Our Ref: R/2015/41/N
File No: 2019/590892

Request for Advice – IMAX Redevelopment (SSD 7388 MOD 10) – 31-33 Wheat Road, Sydney

PUBLIC DOMAIN PLAN

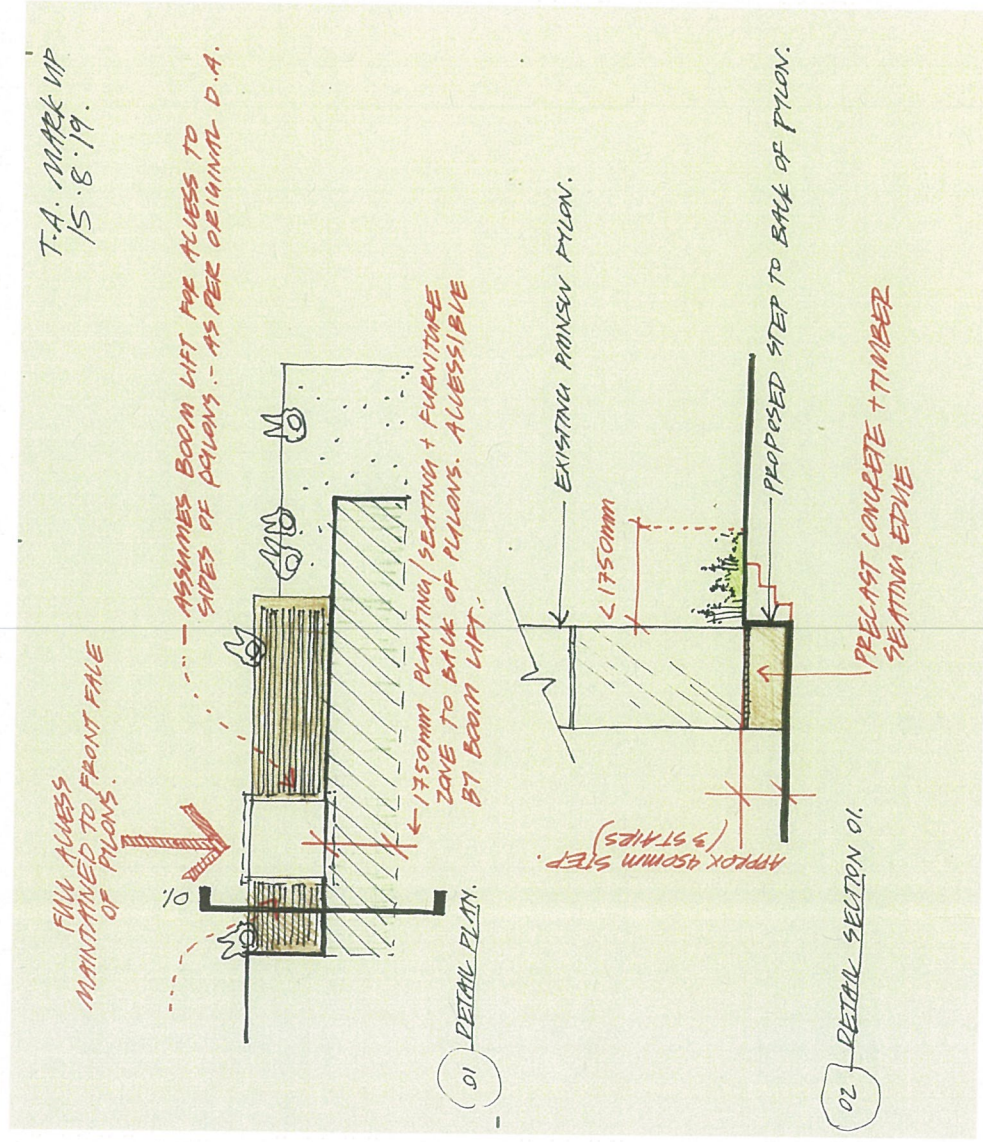
Further, consideration should be given to the cluttering of the public domain and the reduction of clear passageways in this busy area. The width of the upper footway between the north elevation of the Ribbon building to the proposed public domain elements of seating and landscaping has a pinch point adjacent to the proposed outdoor dining areas. The proposed outdoor areas for the Ribbon building is subject to a separate Development Application (D/2019/1231) delegated to the City that is currently under assessment. It proposes outdoor seating widths of approximately 2.3m from the Ribbon building. The City recommends at least a minimum 4m footway width travel path be maintained for a clear path of travel between the proposed public domain embellishments and future outdoor seating zones.

It is considered that the proposed modifications to the playground on the western portion of the site is generally acceptable. However, relocation of the palm groves and new seating elements orientated towards the harbour detracts from the usability of the space for events and the visibility of the City Screen that is referenced in the architectural plans. Consideration should be given to views to the screen and potential visual and physical barriers.
